Swalcliffe Park Equestrian Ltd
Swalcliffe Park Equestrian
Park Lane
Swalcliffe
OX15 5EU

19/02261/DISC

Proposal: Discharge of condition 3 (construction traffic management plan), 4 (landscaping scheme) and 6 (biodiversity method statement) of 19/00171/F

Report type: Delegated

**Detailed description of construction routes from Taylor Farms & external roadways to site of vet building.**

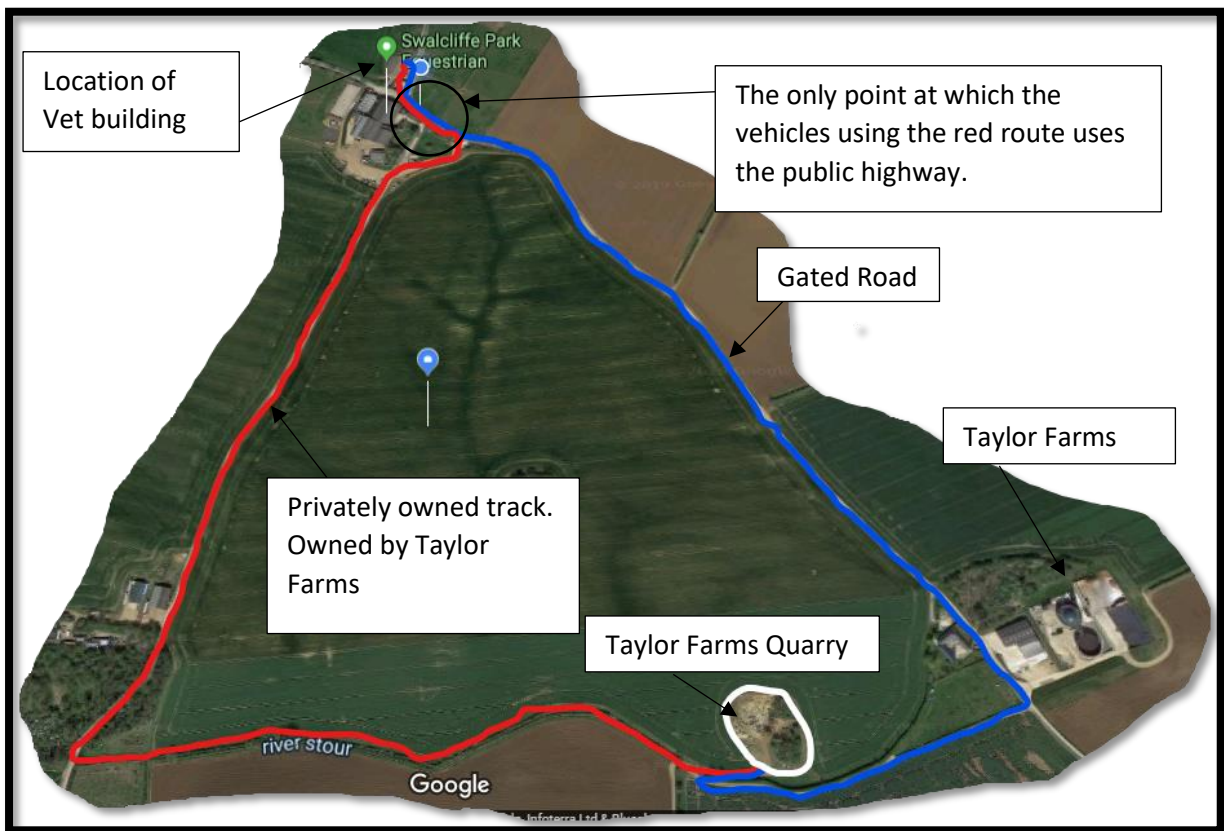
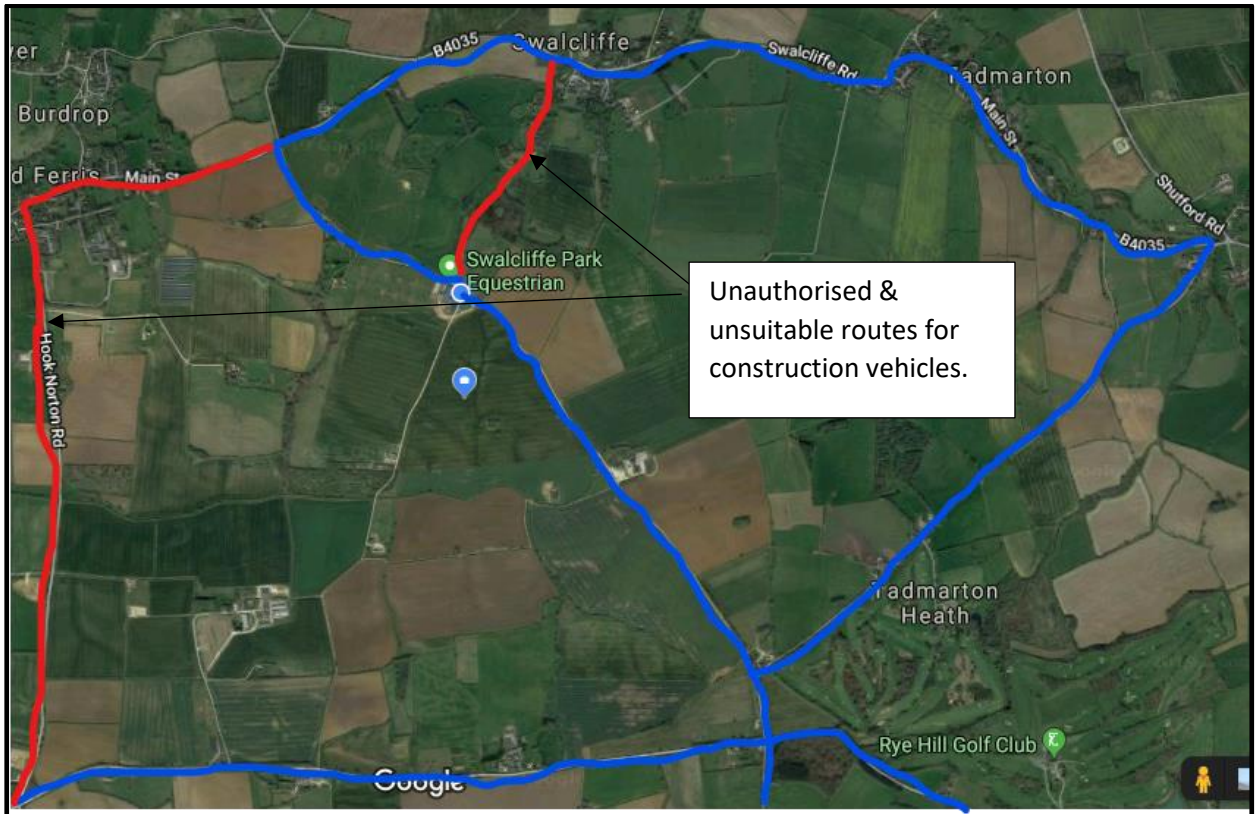
Condition 3 requires a construction traffic management plan (CTMP) to be submitted to and approved in writing by the local planning authority. A CTMP has been submitted as part of the application. The Highways Authority initially objected as the CTMP did not include construction routes or delivery times. This information was subsequently provided and the Highways Officer removed the objection. The CTMP is therefore considered to be acceptable.

Title: Landscape Strategy

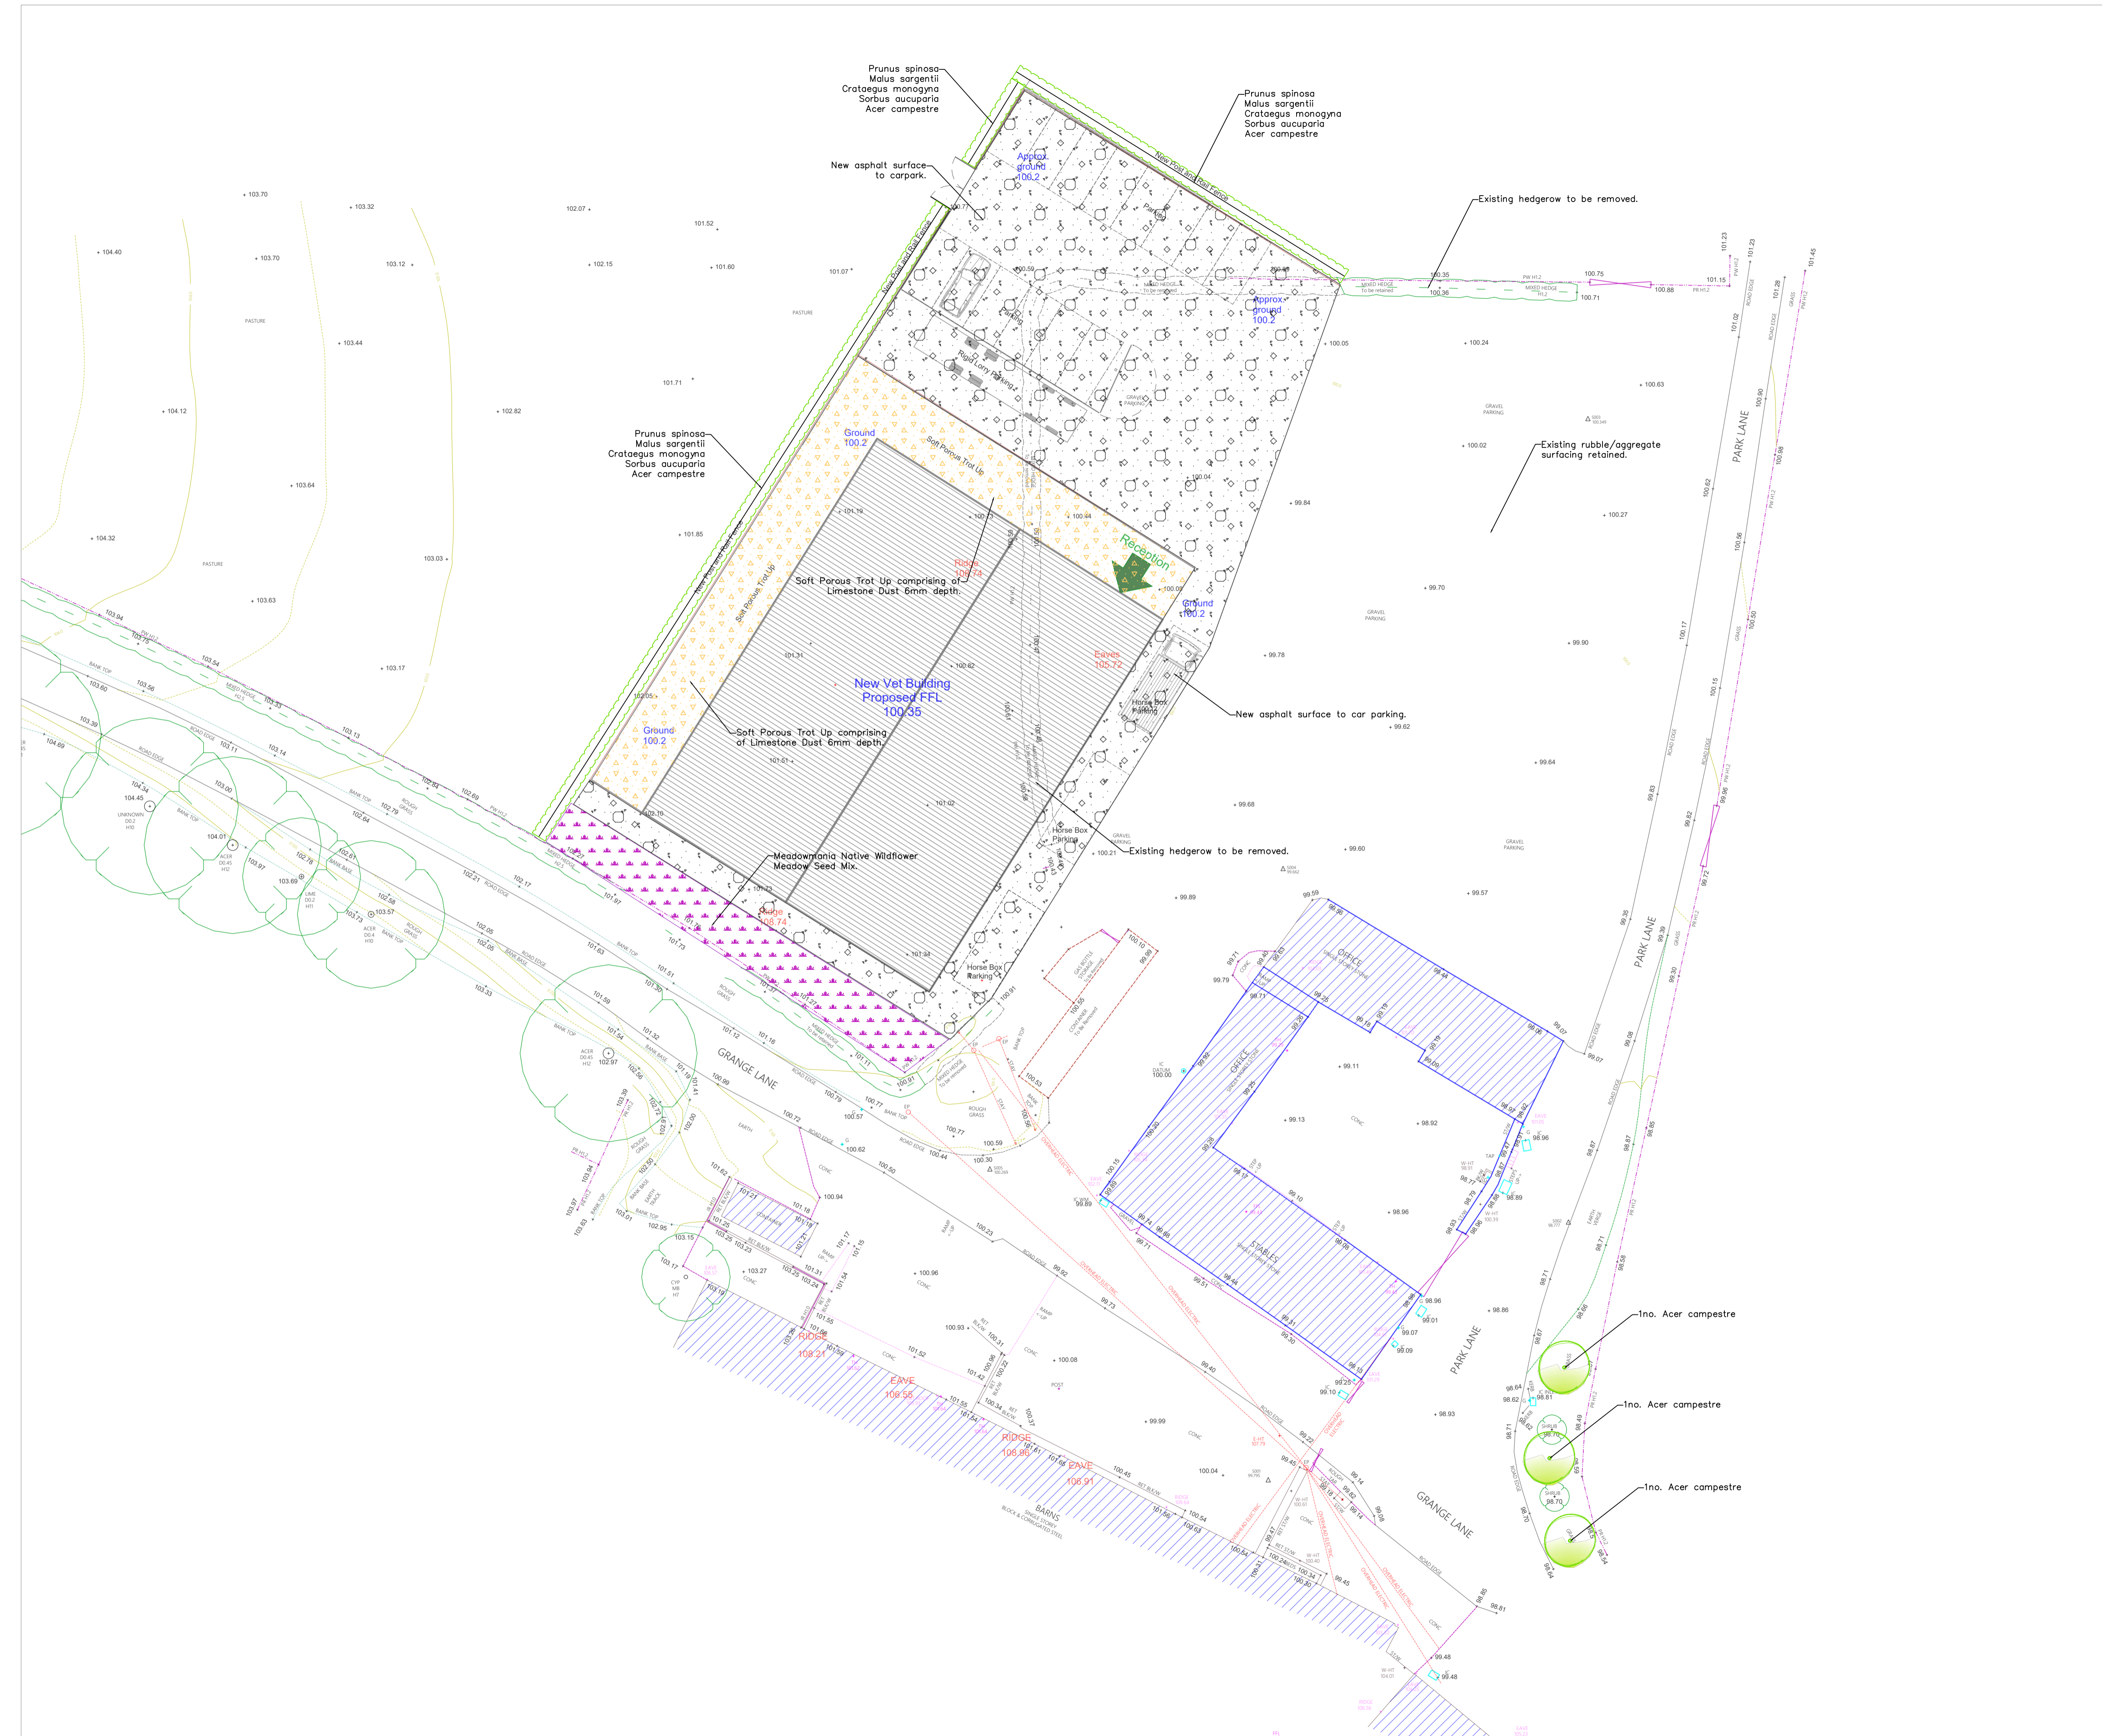
Condition 4 requires a landscaping scheme to be submitted and approved in writing by the local planning authority. The Landscape Officer requested a landscaping scheme to be submitted as no planting was proposed on the north and west boundaries of the site and an existing hedgerow was being removed.

A Landscaping and Ecological Enhancement Scheme prepared by Wharton Consultants has been supplied as part of the application and within this document is a Landscape Strategy (drawing number 001 Rev A). The Landscape Officer has not commented on this discharge of condition. However, the landscaping scheme within this document provides tree, hedgerow and wildflower mix planting. This would include a mixed species hedgerow along the northern and western boundaries of the site. The submitted scheme is considered to be acceptable.
